From: Cornelis Duba <Cornelis.Duba@endeavourenergy.com.au>
Sent: Tuesday, 24 November 2020 8:00 AM
To: Jenny Chu
Cc: DPE CSE Information Planning Mailbox; Jeff Smith
Subject: NSW Planning, Industry and Environment Request for SEARs SSD-11070211 New Public School at Mulgoa Rise, Glenmore Park
Attachments: ENA EMF What We Know.pdf; EE Safety Plumbing.pdf; EE Safety on the job.pdf; EE MDI0044 Easements and Property Tenure.pdf; EE Guide for Padmount Substations.pdf; EE FPJ 6007 Technical Review Request Aug 2019.pdf; SW08773 Work near underground assets.pdf

I refer to the your below email of 13 November 2020 regarding the request for Secretary's Environmental Assessment Requirements (SEARs) for State Significant Development SSD-11070211 New Public School at Mulgoa Rise, Glenmore Park at 1-23 Forestwood Drive, Glenmore Park (Lot 1663 DP 1166869) in the City of Penrith Local Government Area (LGA). Submissions need to be made to the Department by 27 November 2020.

Client NSW DEPARTMENT OF EDUCATION
Drawing title
PLAN OF DETAIL AND LEVELS OVER LOT 1663 IN DP1166869
KNOWN AS 1-23 FORESTWOOD DRIVE, GLENMORE PARK

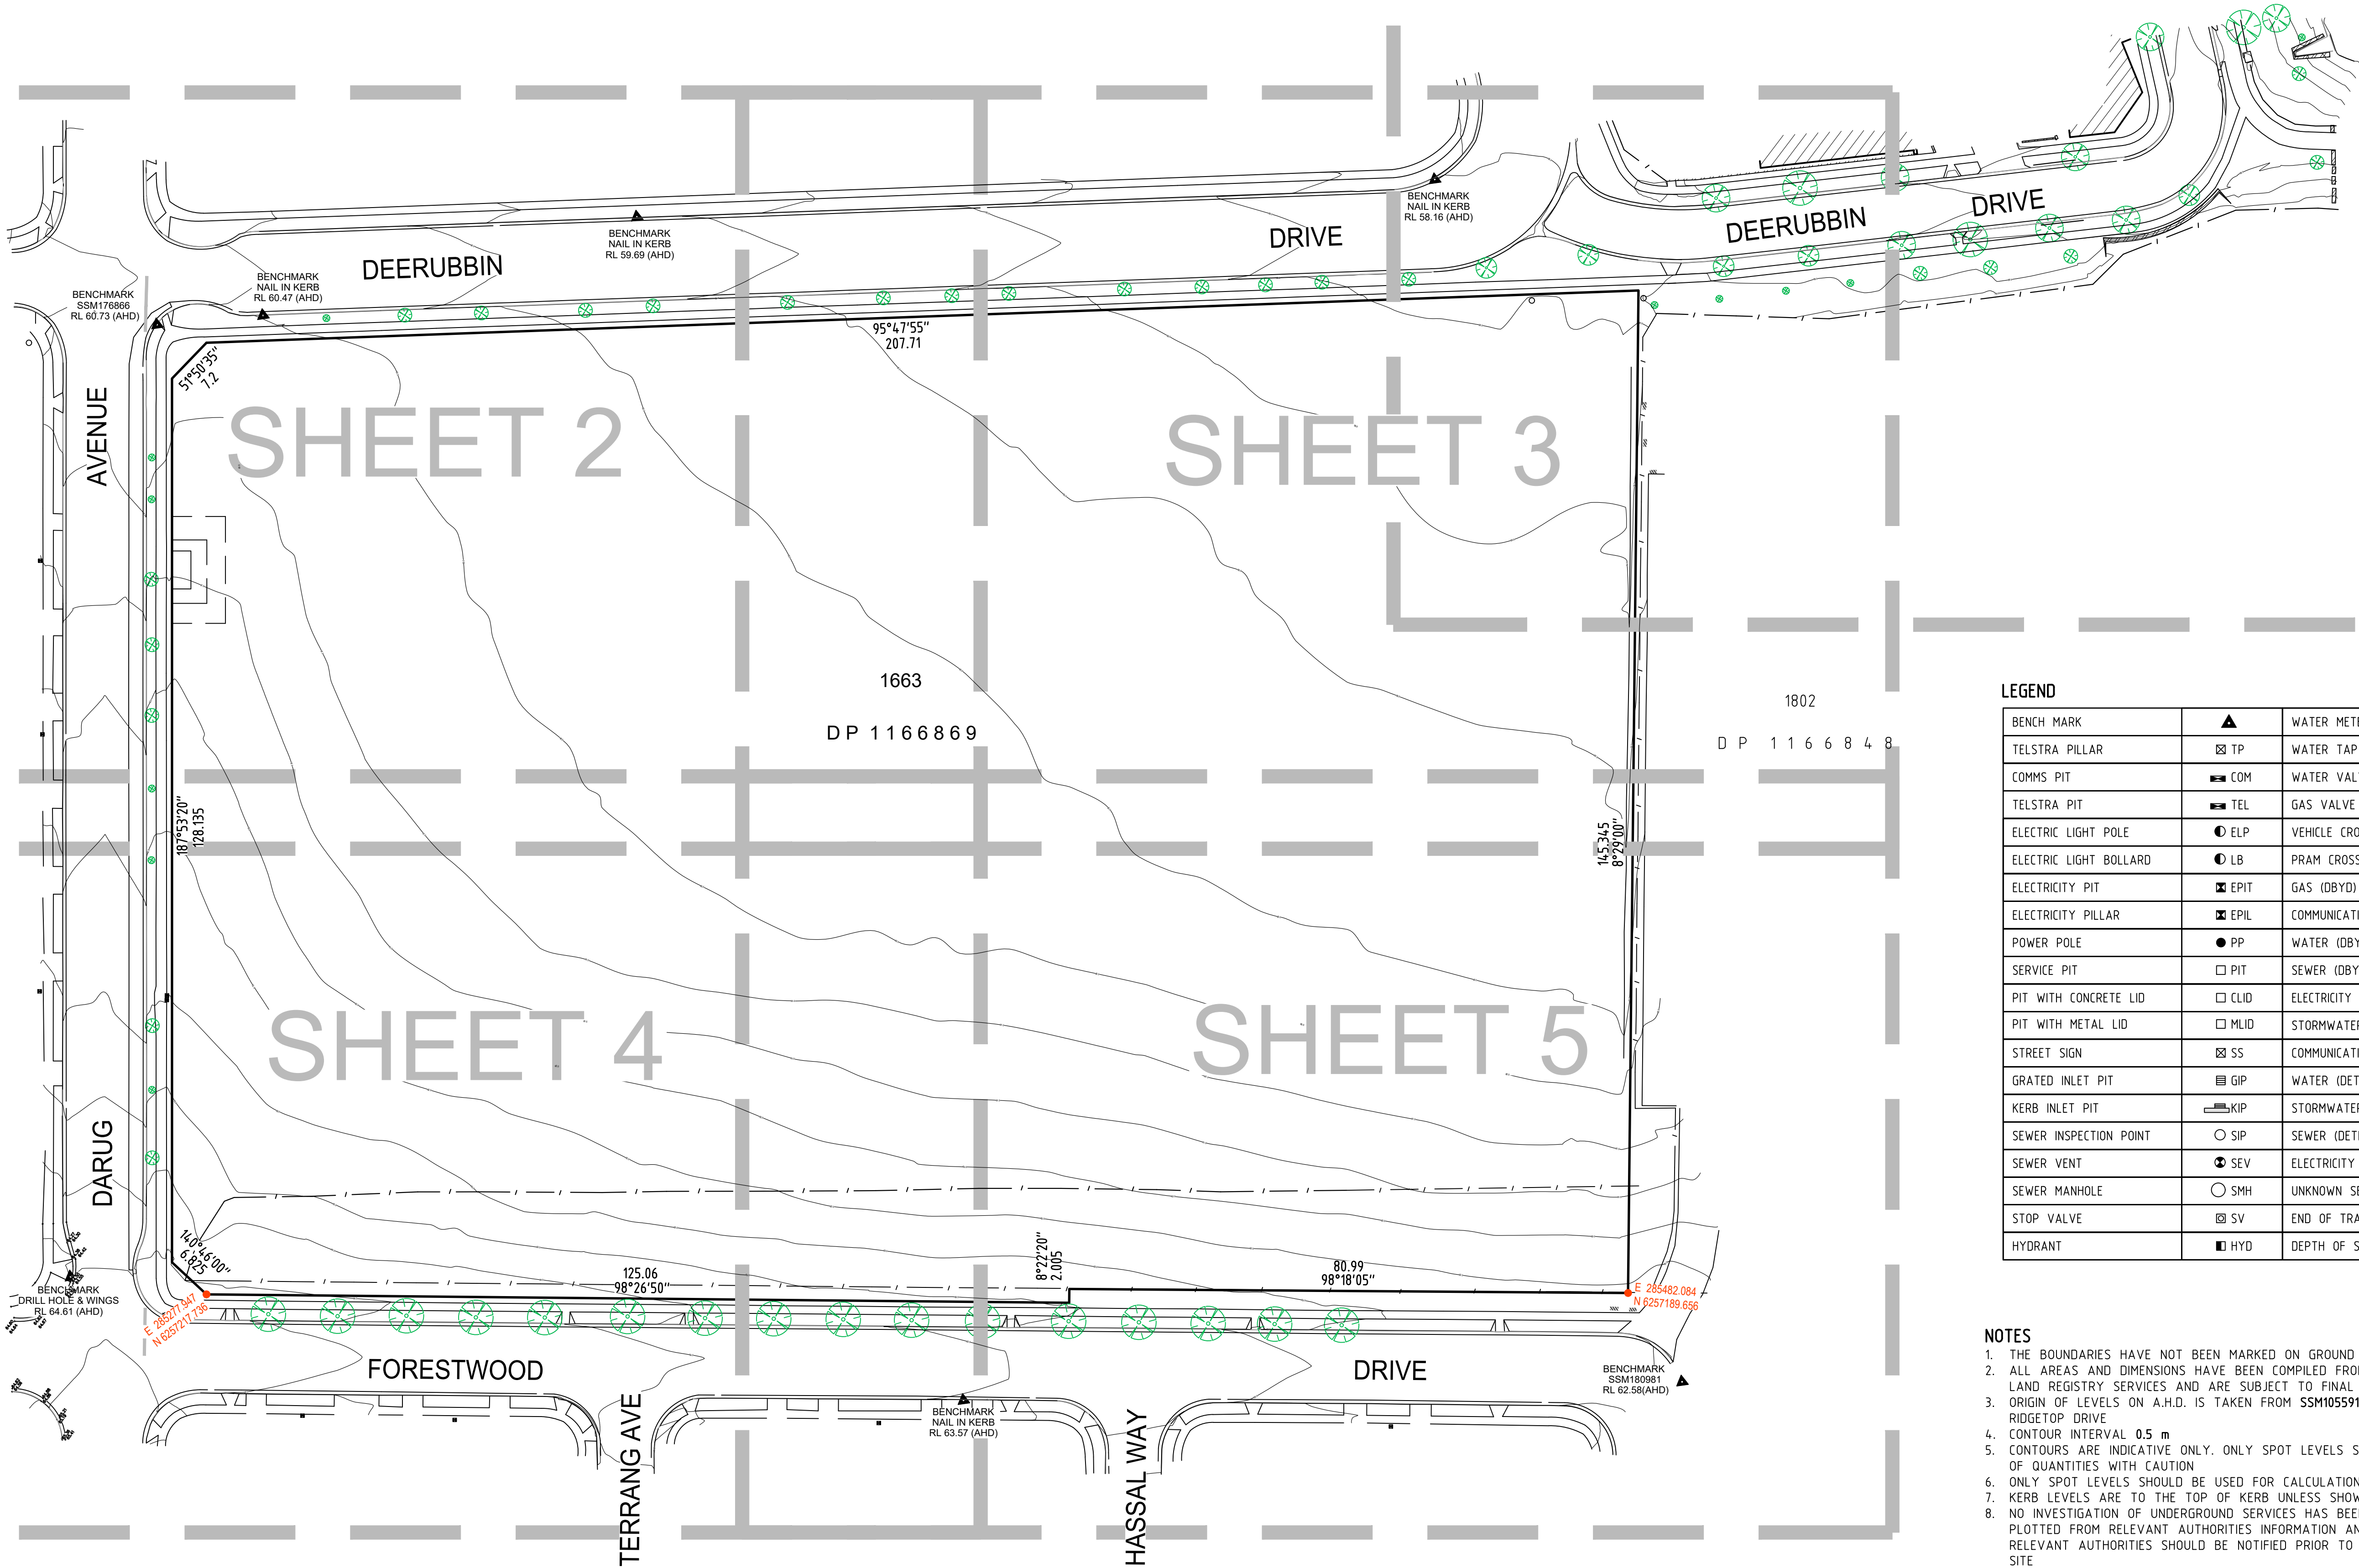
- An easement and restrictions benefitting Endeavour Energy (indicated by red hatching) for padmount substation no. 29097 (indicated by the symbol ).
- Low voltage and 11,000 volt / 11 kilovolt (kV) high voltage underground cables to the Darug Avenue road verge / roadway.
- Low voltage underground cables to part of the Forestwood Drive road verge / roadway.

In regard to padmount substation no. 29097 located on the site, as shown in the following extracts of DP 1161693 in addition to the easement there are additional restrictions / clearances for:

- Fire rating which usually extends 3 metres horizontally from the base of the substation footing and 6 metres vertically from the same point.

- Swimming pools which extends 5 metres from the easement.
